Our ref: HA/2019/121229/01-L01
Your ref: BR/87/19/PL
Date: 11 April 2019

**CHANGE OF USE OF PARTS OF SEAFRONT FOR TEMPORARY FOOD & DRINK
OUTLETS & OTHER SEASIDE USES TOGETHER WITH ASSOCIATED
TEMPORARY/PORTABLE STRUCTURES & EQUIPMENT FOR USE BY
BUSINESSES ASSOCIATED WITH THOSE OUTLETS.**

VARIOUS SITES ALONG BOGNOR REGIS PROMENADE BOGNOR REGIS

BLOCK PLANS - SHEET 1 OF 2

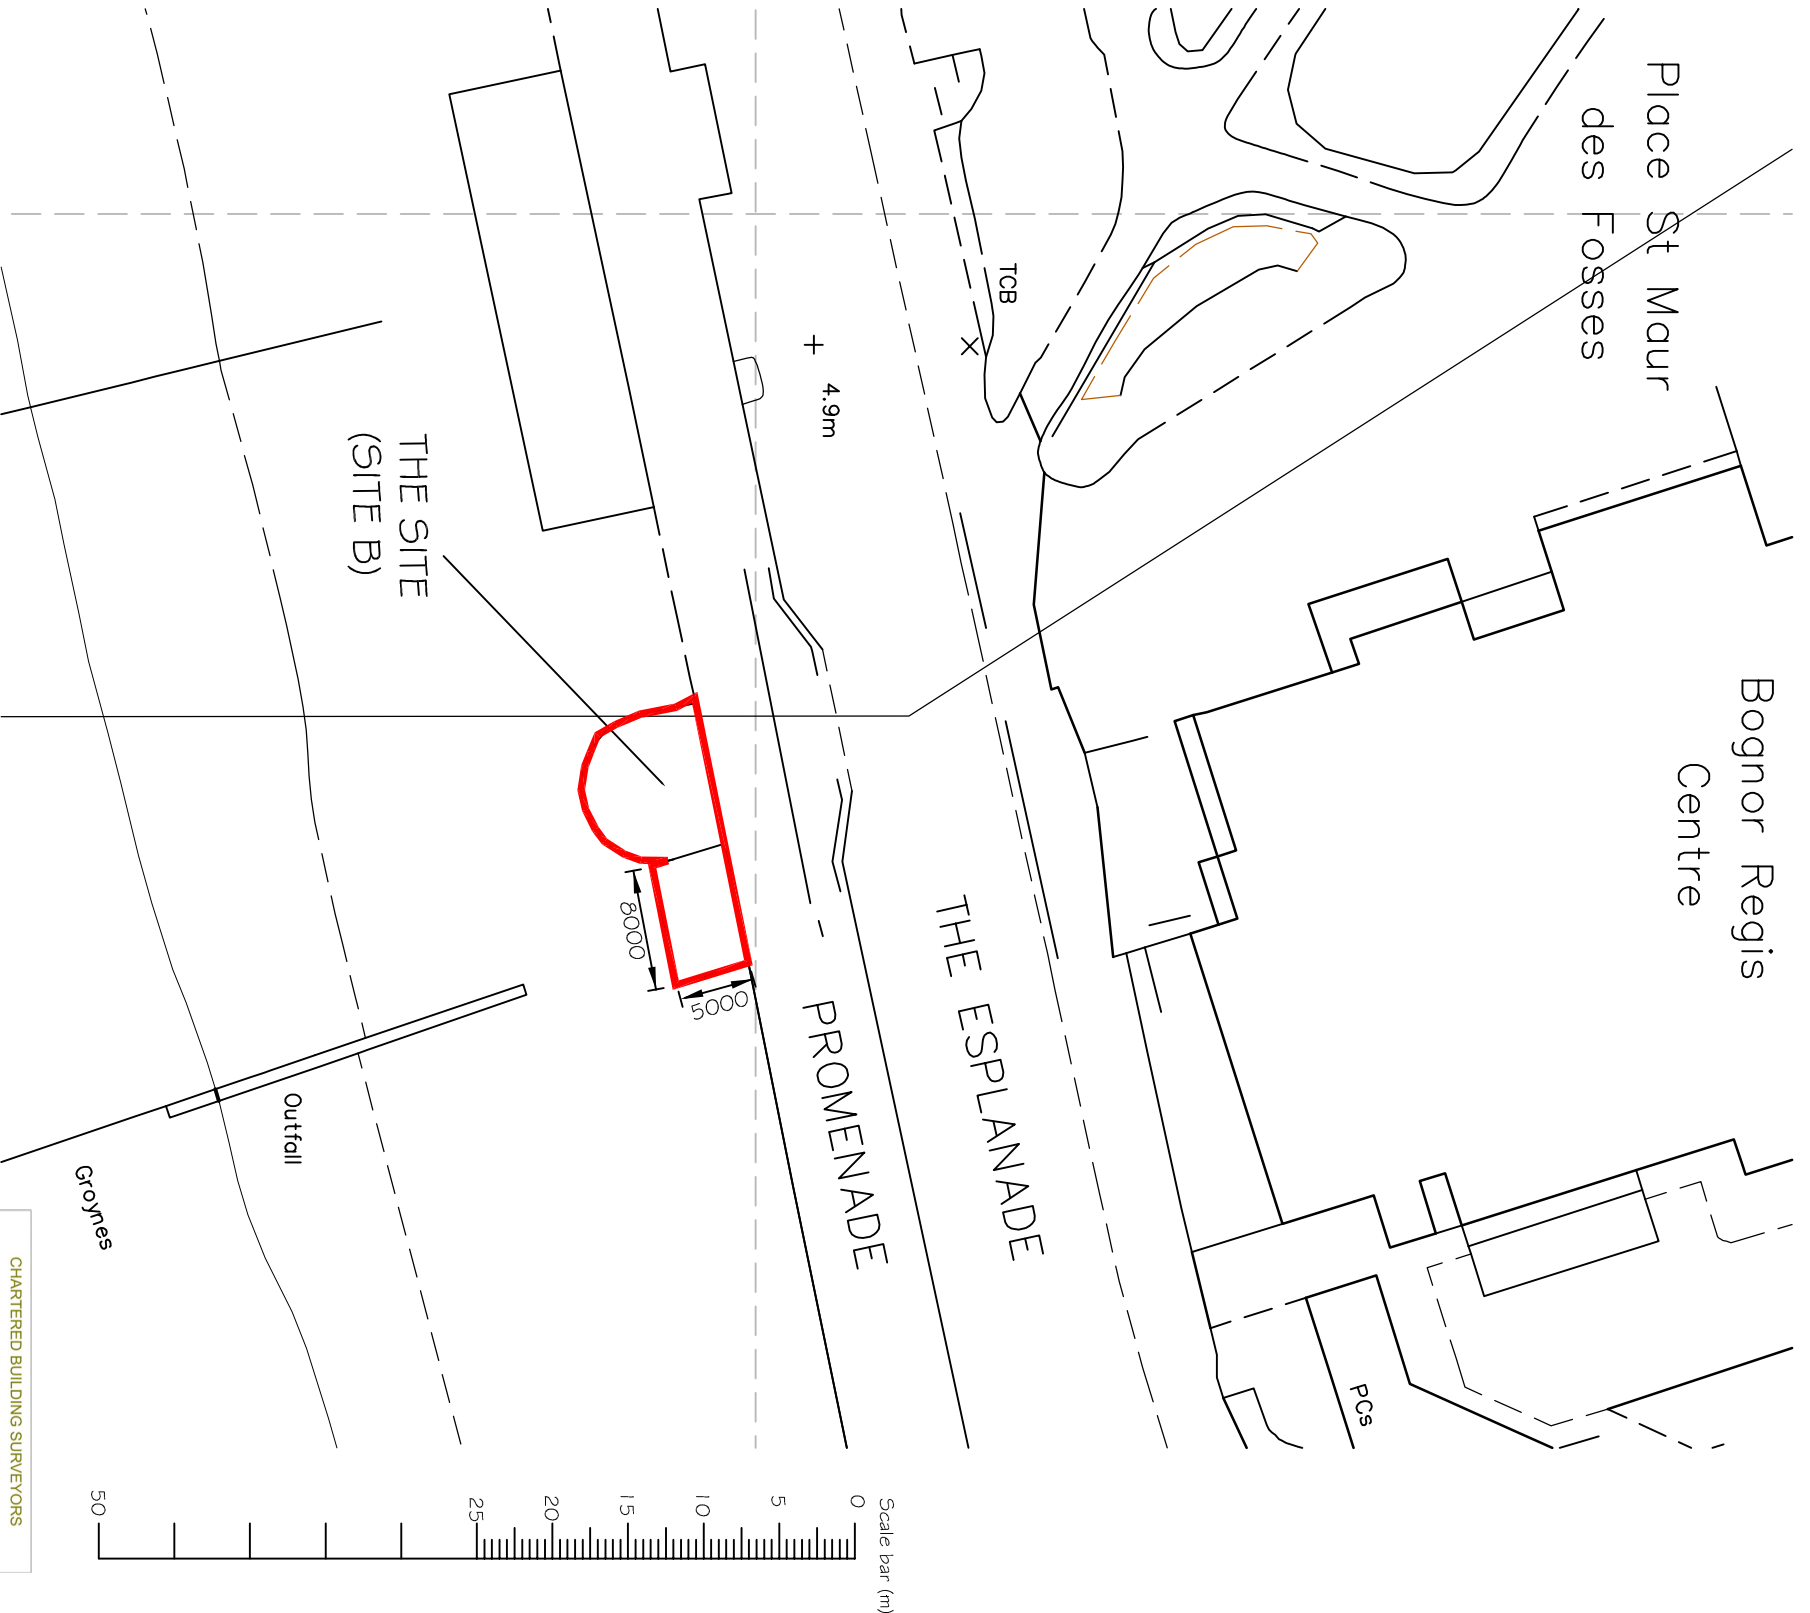
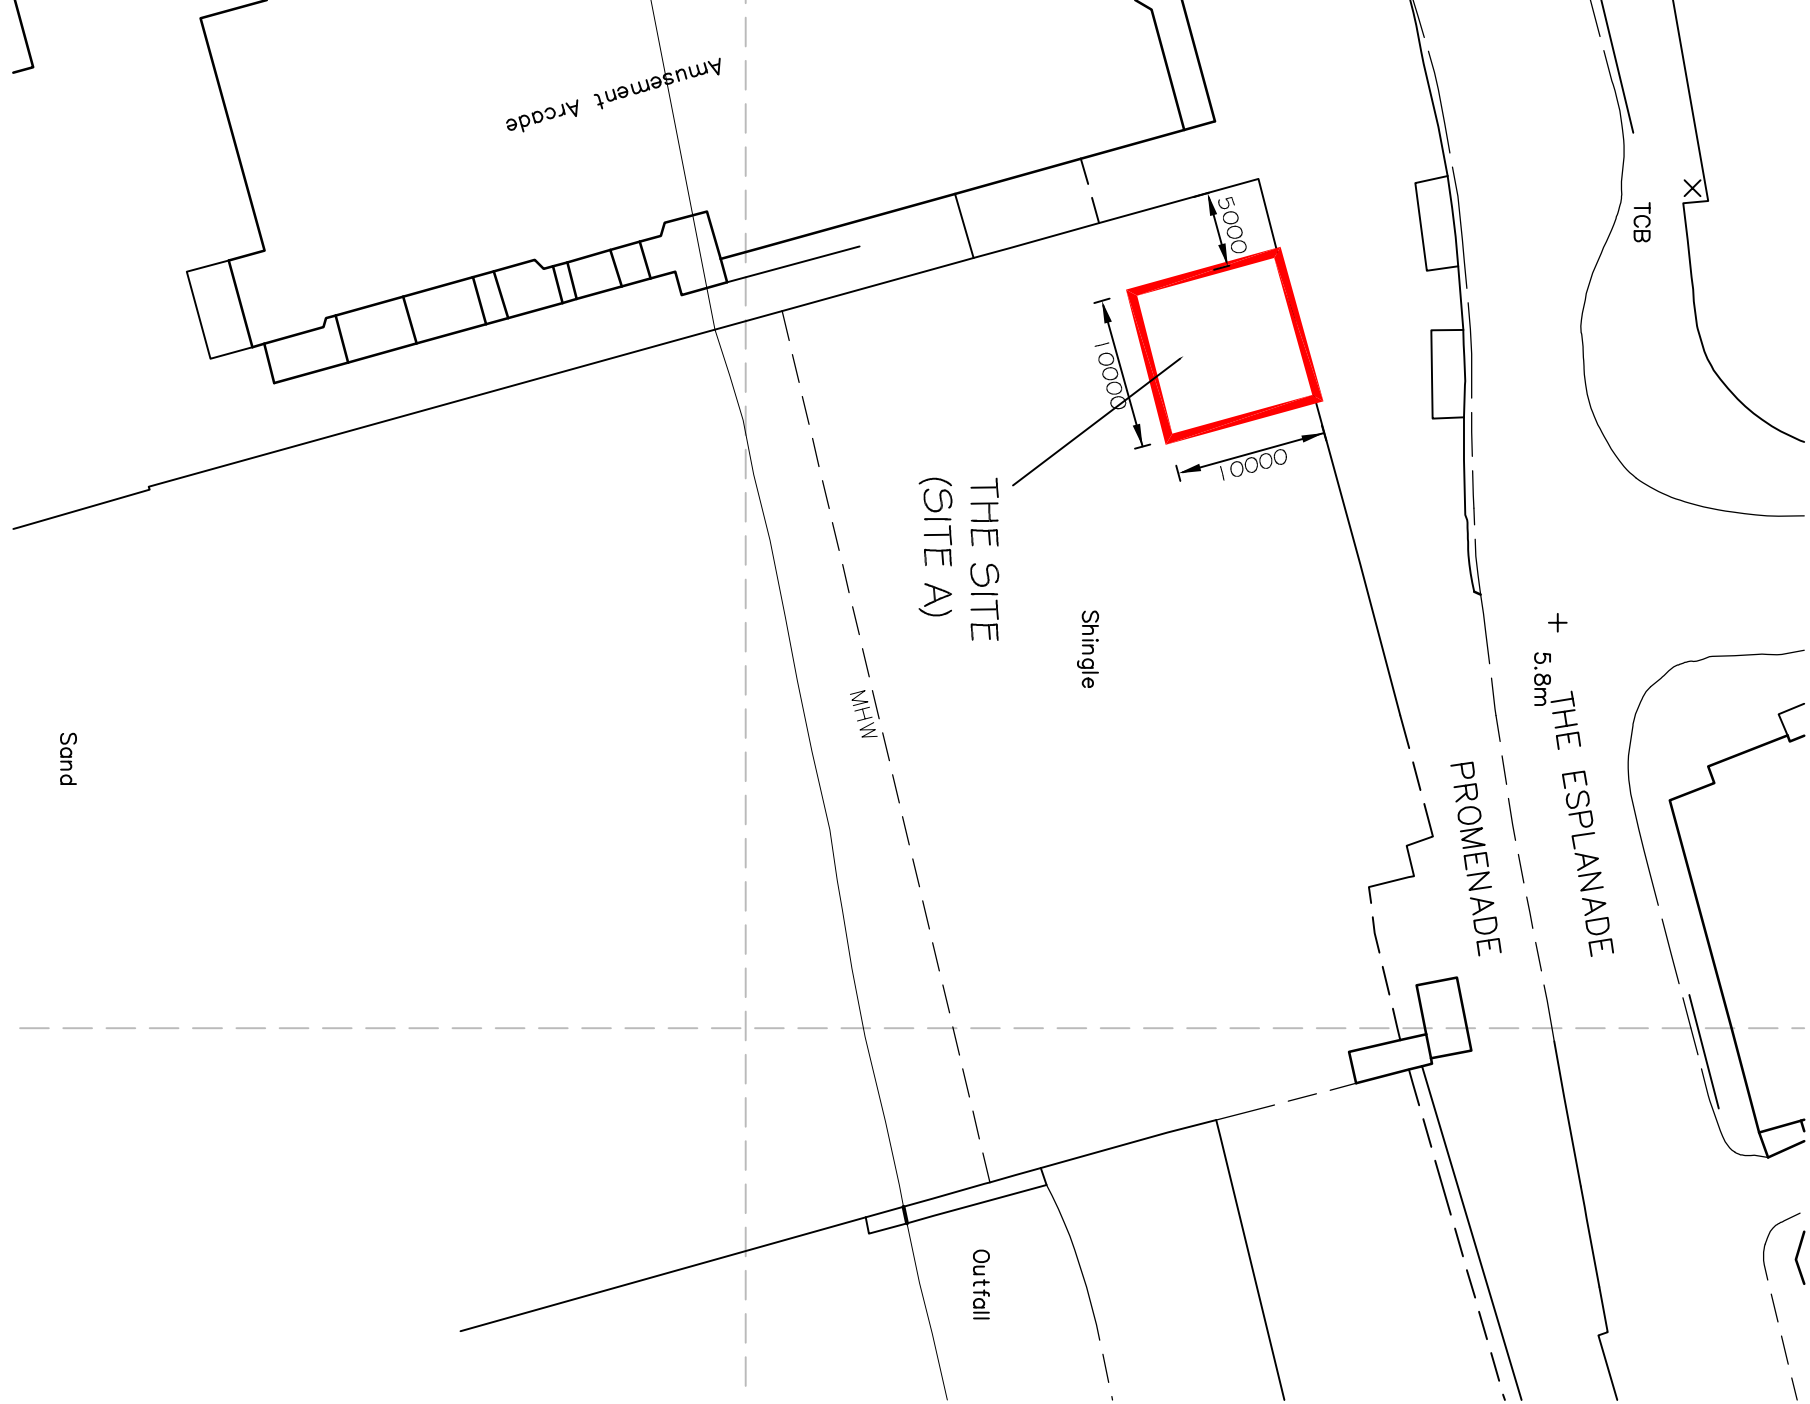
We have no objections to the proposed change of use. However, we would recommend that temporary structures are kept within the confines of the site plans and do not block the entirety of the promenade or access routes to ensure we can still gain access to the beach for our operational requirements is our main concern.
